Response to Planning Application

Application ref: LU/369/21/RES

Description: Approval of reserved matters following outline consent LU/47/11/ (amended under LU/182/15/PL) for the formation of the Central Wetland Area and the construction of the Central Spine Road running across the Central Wetland area, linking up Phase 5 and Phase 2B (also known as Phase 4). This site is in CiL Zone SP2 and is not CIL Liable as strategic site.

Location: Central Wetland Area Hampton Park Toddington Lane Littlehampton BN17 7PL

A088461 SK.CWA.2[D].dwg 25 October 2021

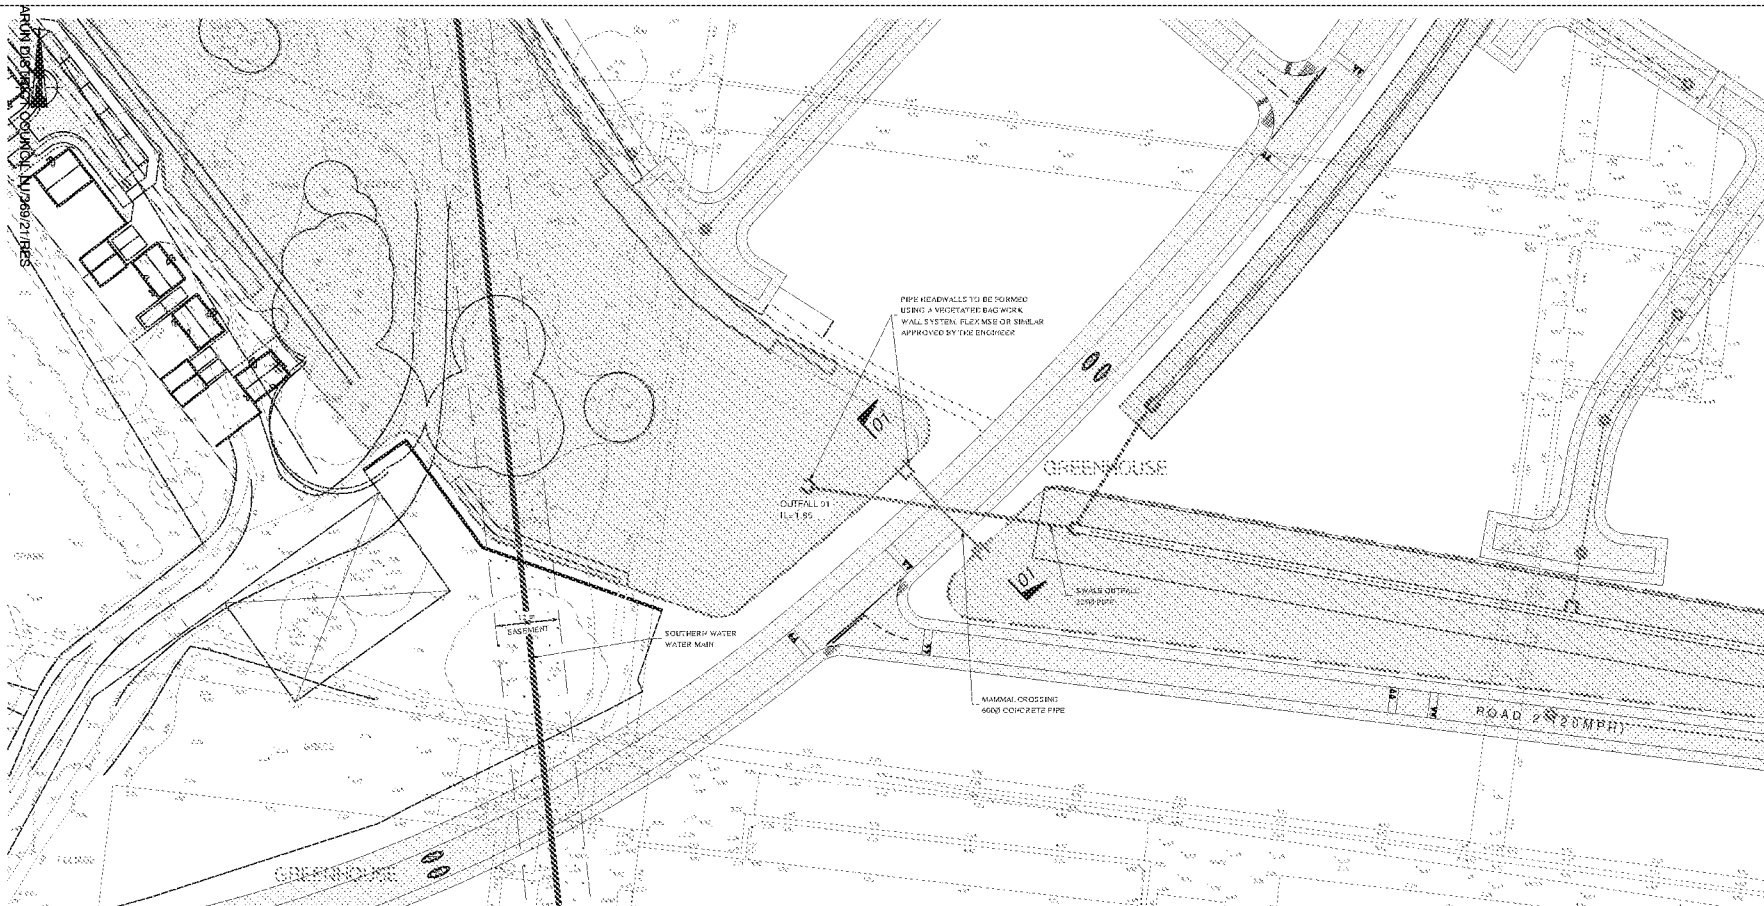
The information submitted in Central Wetland Area Planting Plan drawing A088461 SK.CWA.3(D) dwg 25 October 2021 has not been provided in sufficient detail in order to assess the proposals. The detail fails to represent how the proposed planting will sit in relation to existing, cut and fill and made up ground forms, with planting indicated to sloping ground without a clear understanding of how this landform will function. The above plan provides only an indicative representation of the landscape proposals and is required in much greater detail. One submitted landscape plan is not sufficient enough detail for such an intrinsic area of this development.

The planting mix suggests the planting of 152no new standard or larger trees to be planted with 2919no smaller less than 1m in height transplants of limited species mix for the entire Central Wetland area. Note should be made that no evergreen species have been included within what is a fairly limited plant selection mix. Evergreens along with fruit bearing species have a role to play for biodiversity purposes and should be included within the proposed selection. Tree planting detail

along with tree protection methods and maintenance operations need to be submitted along with these proposals.
